Address: Nos. 134 – 144 Pitt Street, Redfern
Proposal: Mixed Use Development
OCTOBER 2017

RESPONSE TO SUBMISSIONS

RESPONSE TO SUBMISSIONS
FORMER RACHEL FORSTER HOSPITAL
NOS. 134 – 144 PITT STREET, REDFERN

PREPARED FOR KAYMET CORPORATION PTY LTD

BUILDING B - EAST ELEVATION SHADOW (JUNE)

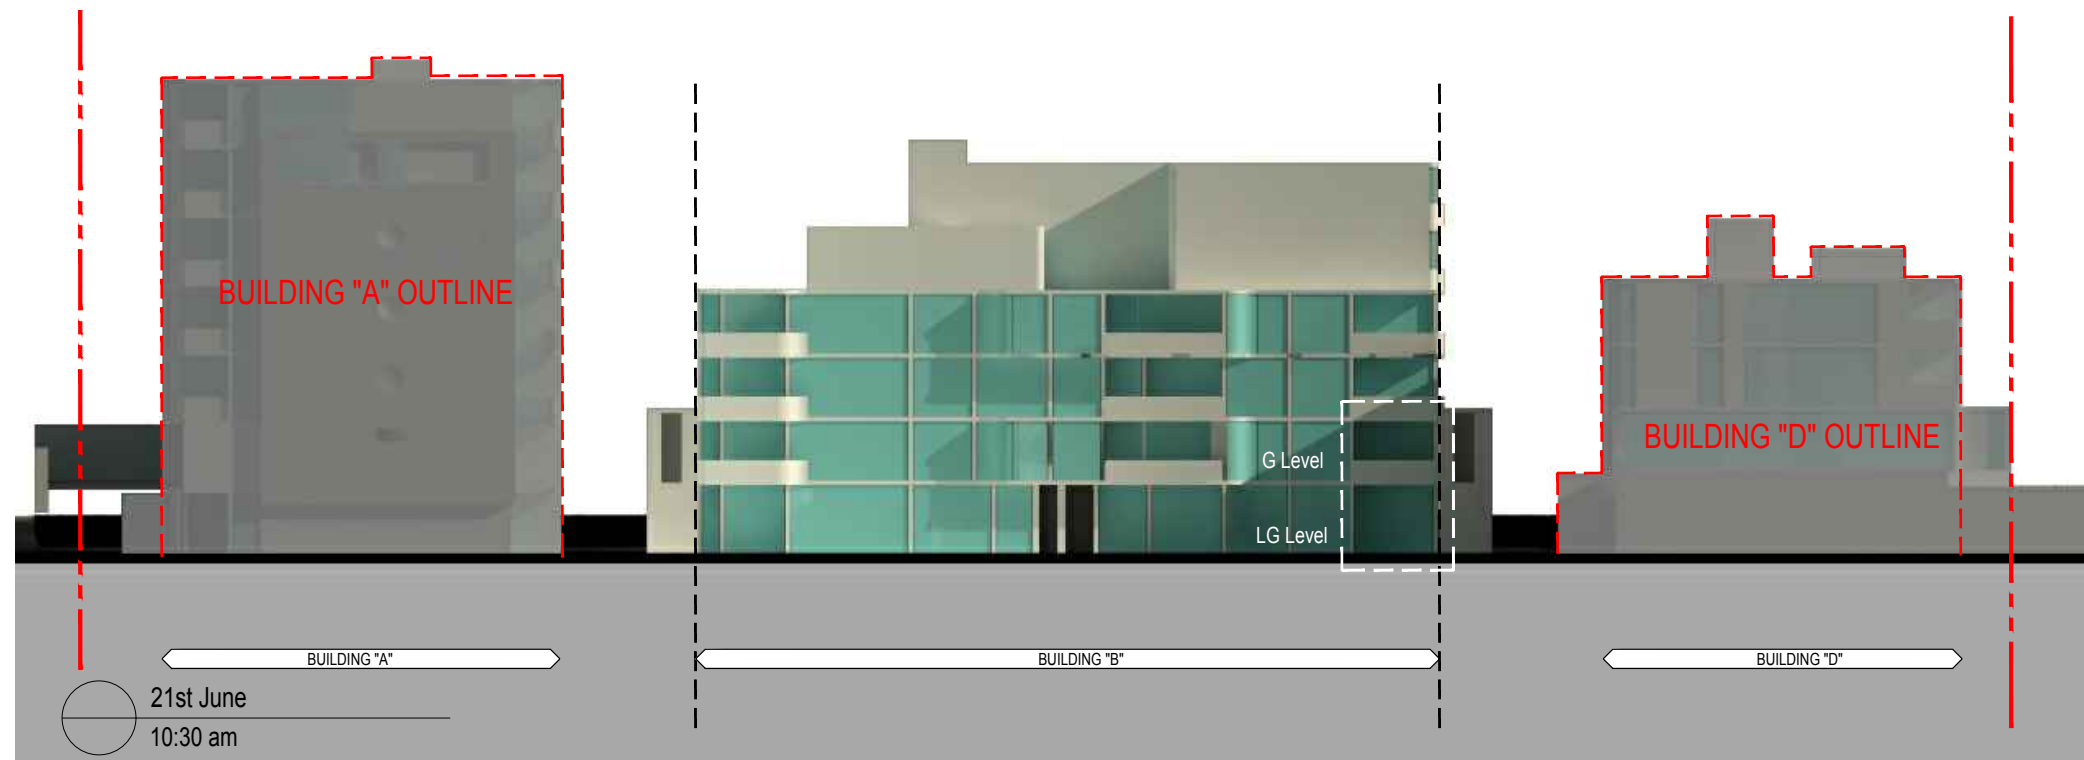
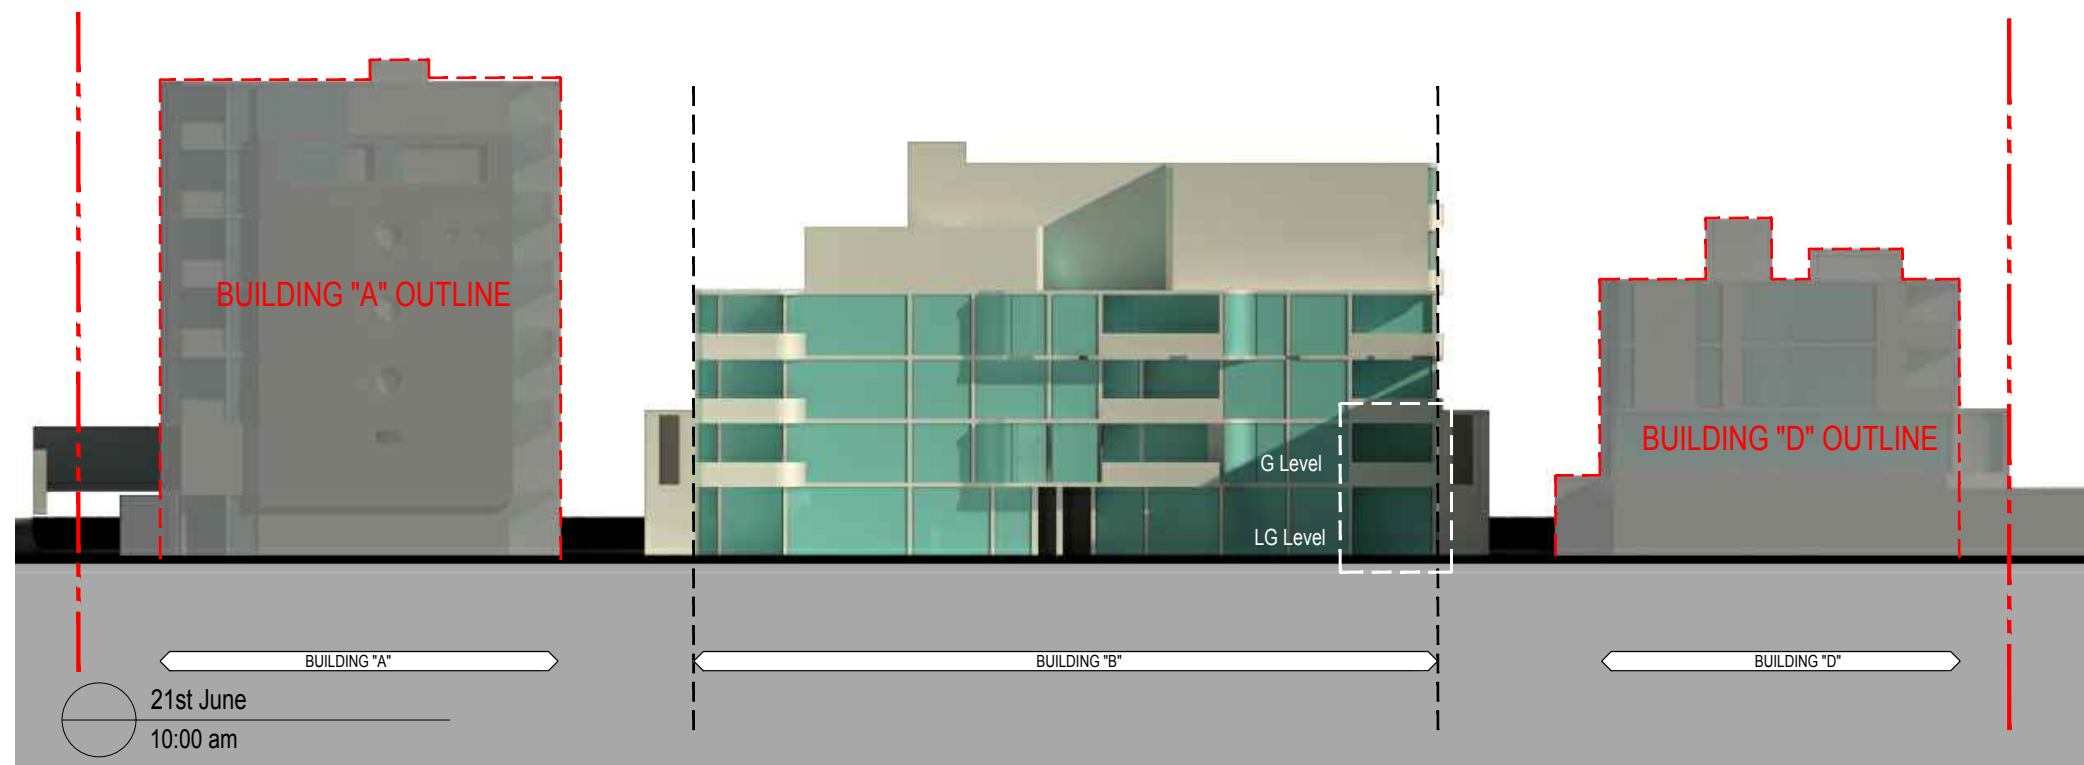
- 14) *Solar access:*
